Application Correspondence "Discussions with Engineers regarding easement to the ditch"

From: Paul Cann <Paul.Cann@arun.gov.uk>
Sent: 04 November 2020 15:26
To: Simon Davis <Simon.Davis@arun.gov.uk>
Cc: Daniel Vick <Daniel.Vick@arun.gov.uk>
Subject: RE: AL/64/20/PL - Need for easement from Northern boundary ditch

Plot 6 Floor Plans 1:100@A3

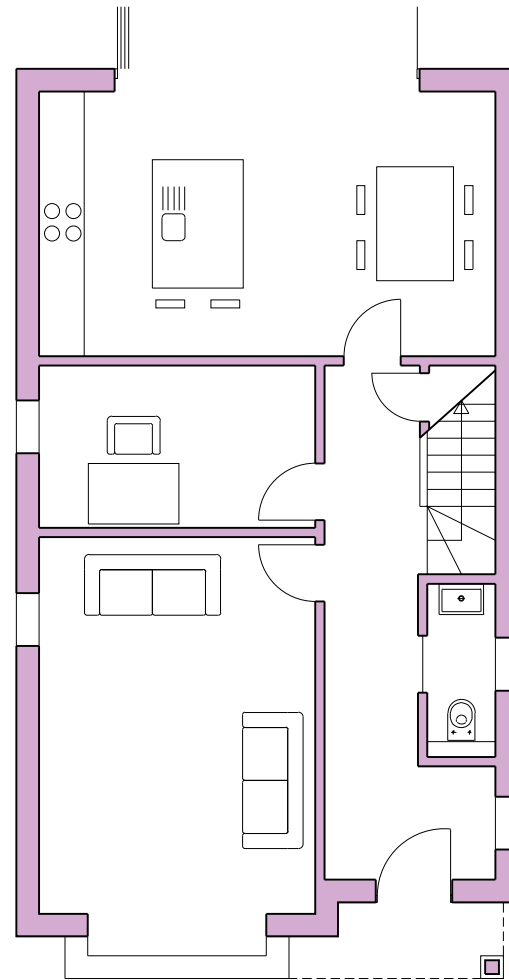
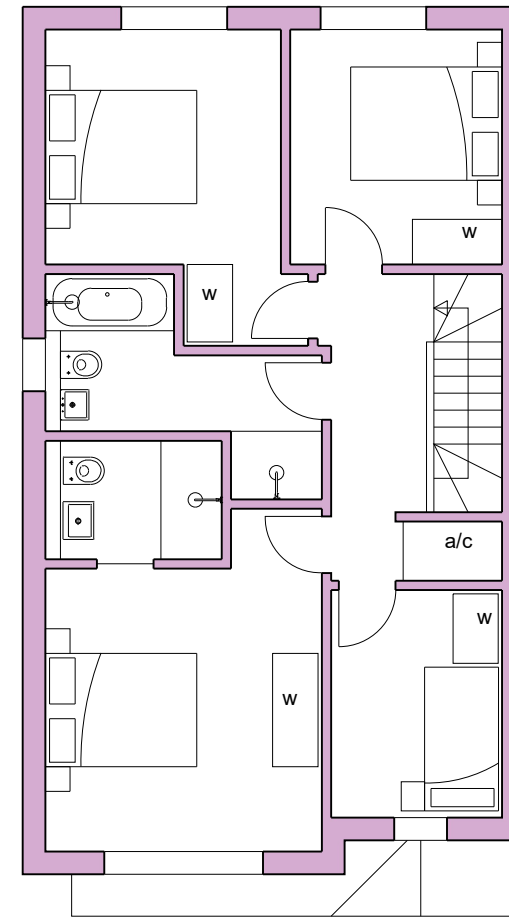
I have assessed plot 6 as being ok in my report due to it having a garden width of 10m therefore even if its rear garden depth is shortened to around 6m, it still retains a decent garden area.

I would like to see this agreed before the layout is agreed. Please note that plot 6 may end with a fairly small back garden so they may need to consider moving the plot. As part of the fencing proposals, they will also need to demonstrate how vehicular access to the 3m maintenance strip is to be gained from the road. Gates etc are likely to be needed.

Plot 8 Floor Plans 1:100@A3

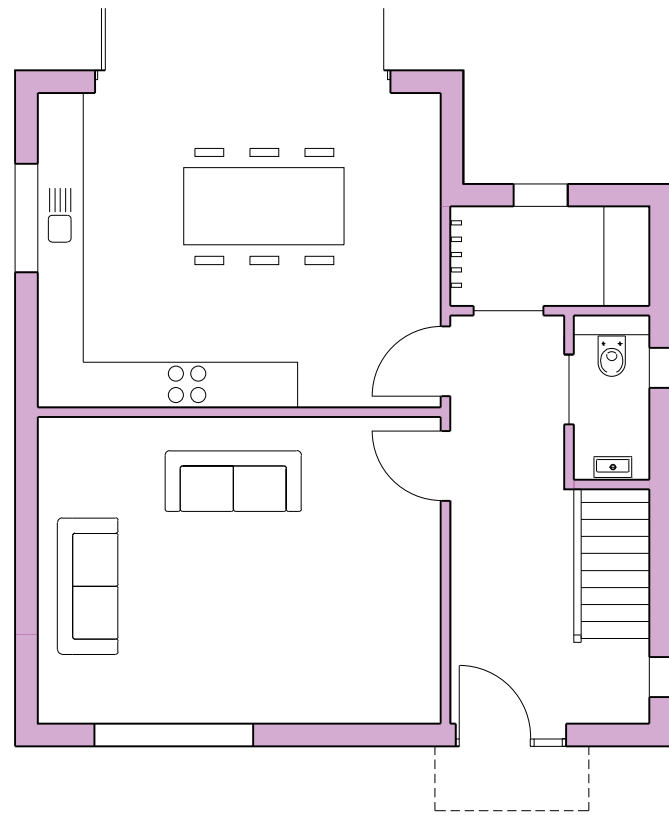
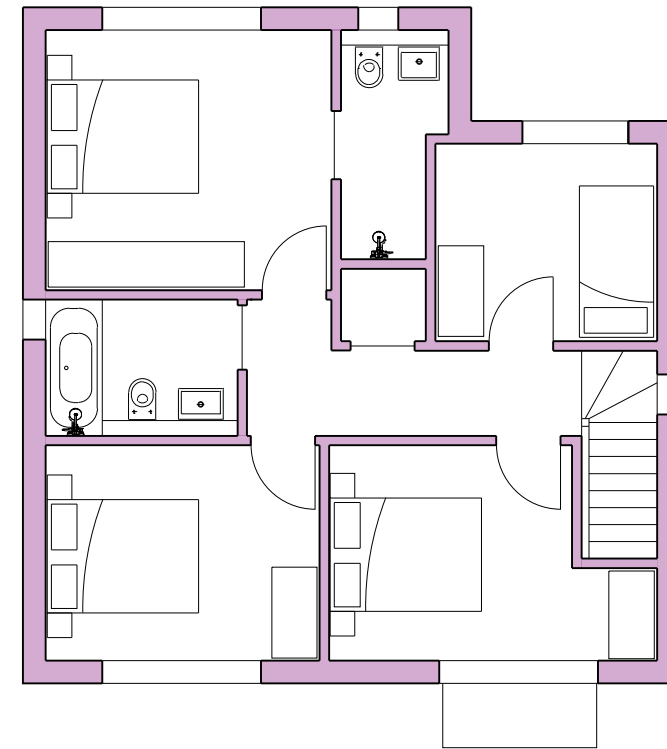
We are pretty sure BDW and the Springfield developer have 50/50 riparian responsibility for the ditch. As Springfield have no right to maintain the ditch from the BDW side they need to have their own arrangements, hence the 3m maintenance strip along the bank. They of course need to get maintenance vehicles to that strip, and adjusting plot 8's garden boundary seems the obvious way to achieve this.
